From: Farhad Khatibi
Sent: 08 April 2024 14:51
To: Planning ContactCentre
Subject: RE: Attached letter from Kirklees Council regarding application number 2023/93661 at location 110, Underbank Old Road, Holmfirth, HD9 1AS

Please arrange for the inclusion of the following conditions:

Drawing:
PROPOSED PLANS.
Project No: Drawing No: 02_03
Scale: Date: May 23 Drawn by: JC Checked by: —

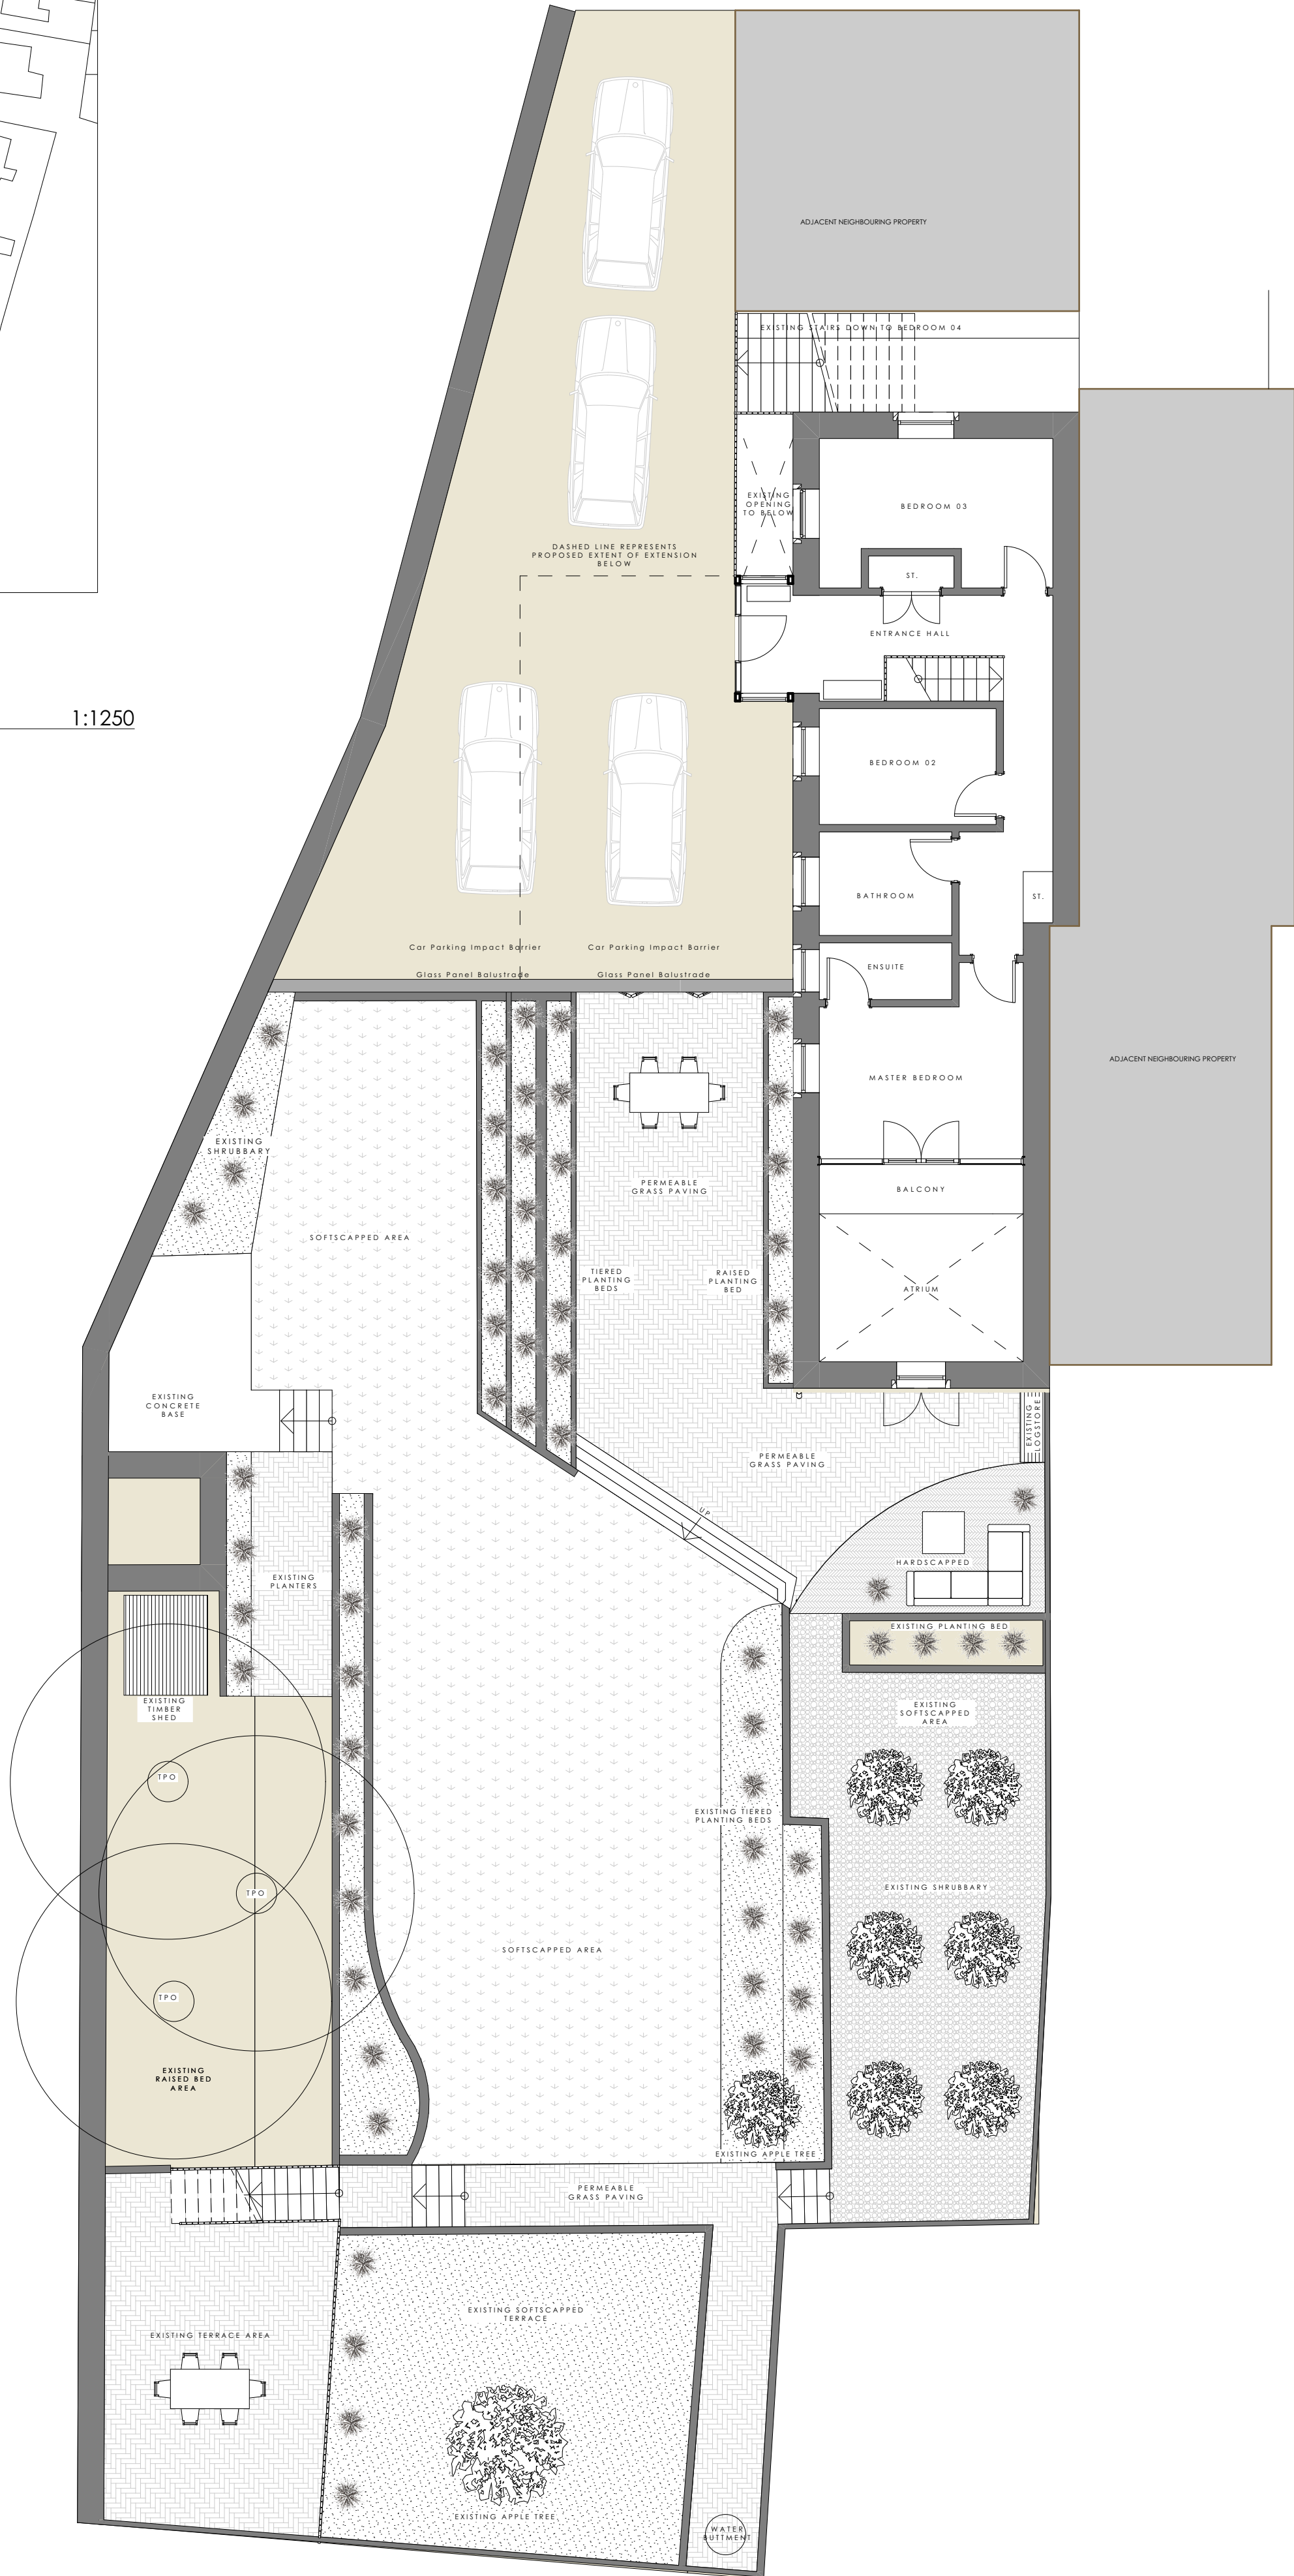
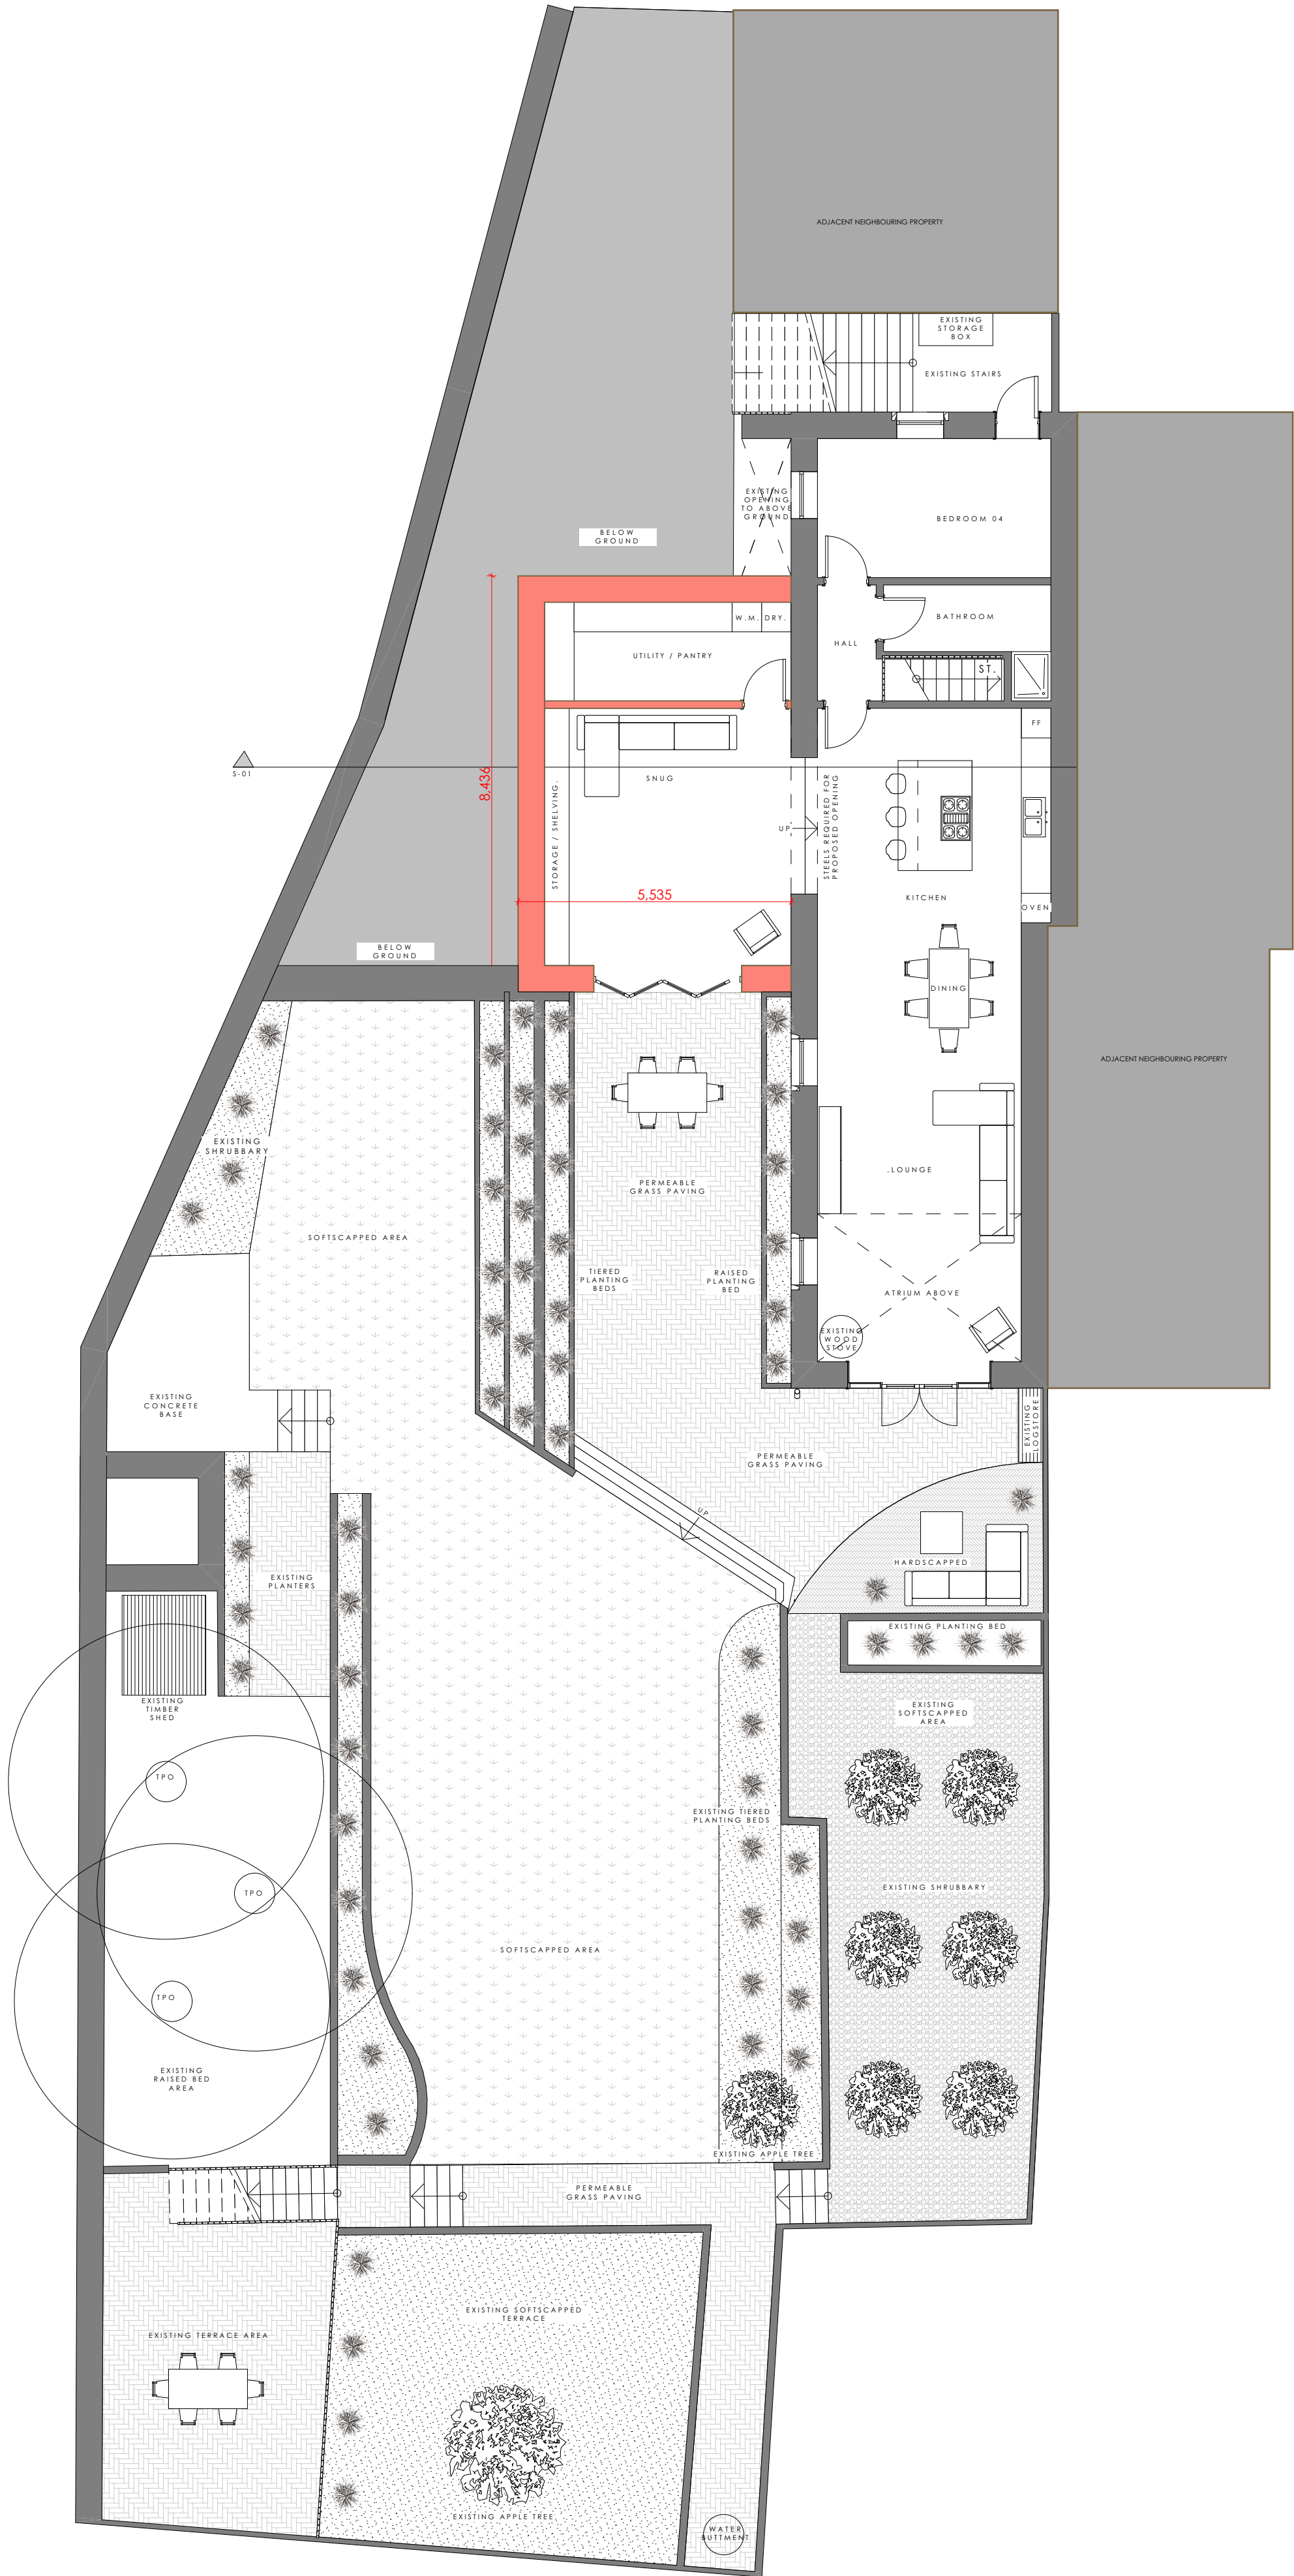
- 1) Before the development commences, the design of proposed temporary/ permanent retaining walls including the basement retaining walls adjacent to the existing highway together with any modification to the existing burr wall supporting Underbank Old Road shall be submitted (via the submission of AIPs) and approved by the Highway Authority in writing. The approved scheme shall be implemented prior to the commencement of the proposed development and thereafter retained during the life of the development.
